From: Andrew Wood
Sent: 09 November 2018 11:19
To: Planning.Responses
Subject: FW: M/125/18/DOC - Middleton House landscaping

I am currently dealing with your application to discharge condition 4 of M/39/17/HH – M/125/18/DOC.

LANDSCAPING PLAN

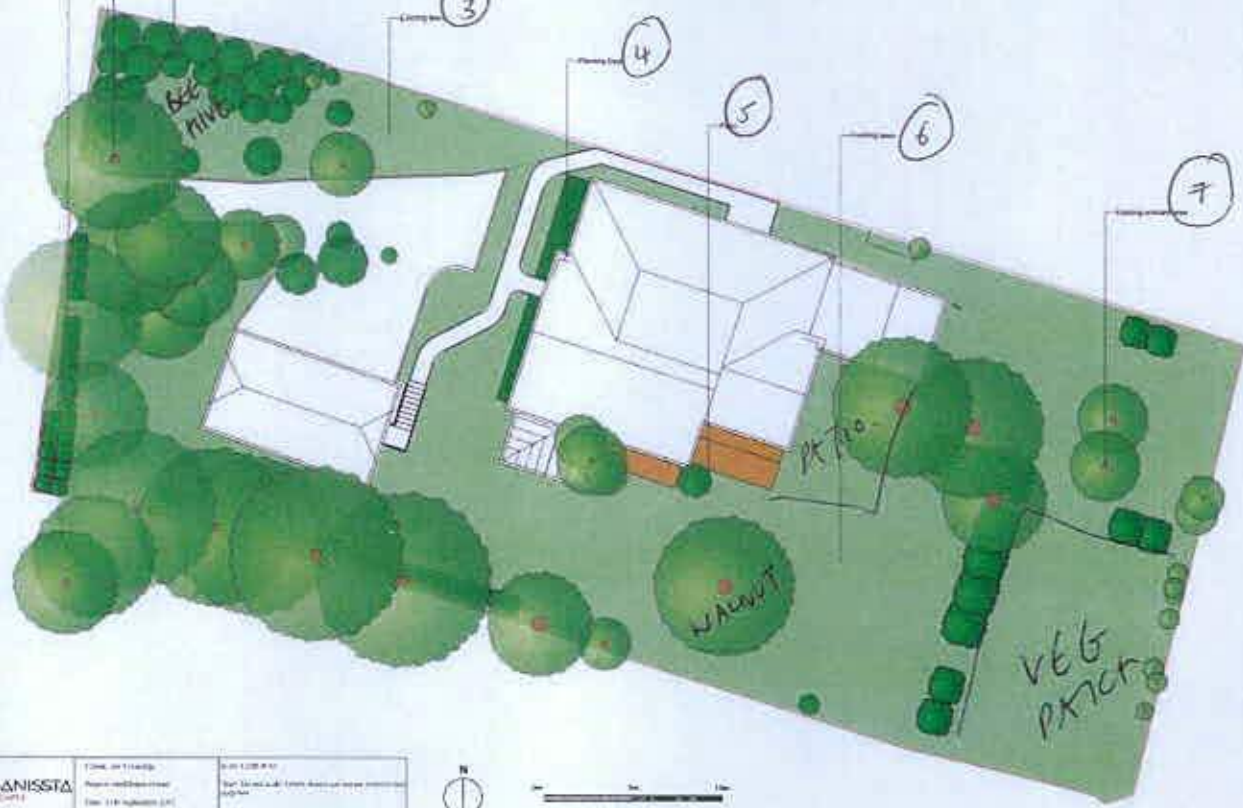
Can you please provide a plan and elevational drawing of the proposed 'tall fence' 3 metres back from the road. It is important that this drawing is drawn to scale. Please indicate the materials of construction of the proposed fence.

I am happy to do so . The fence however is 2/3 completed (we have naughty escape artists dogs so will have to have a fence anyway) so I have attached photos which might be sufficient. Let me know if you still need drawings
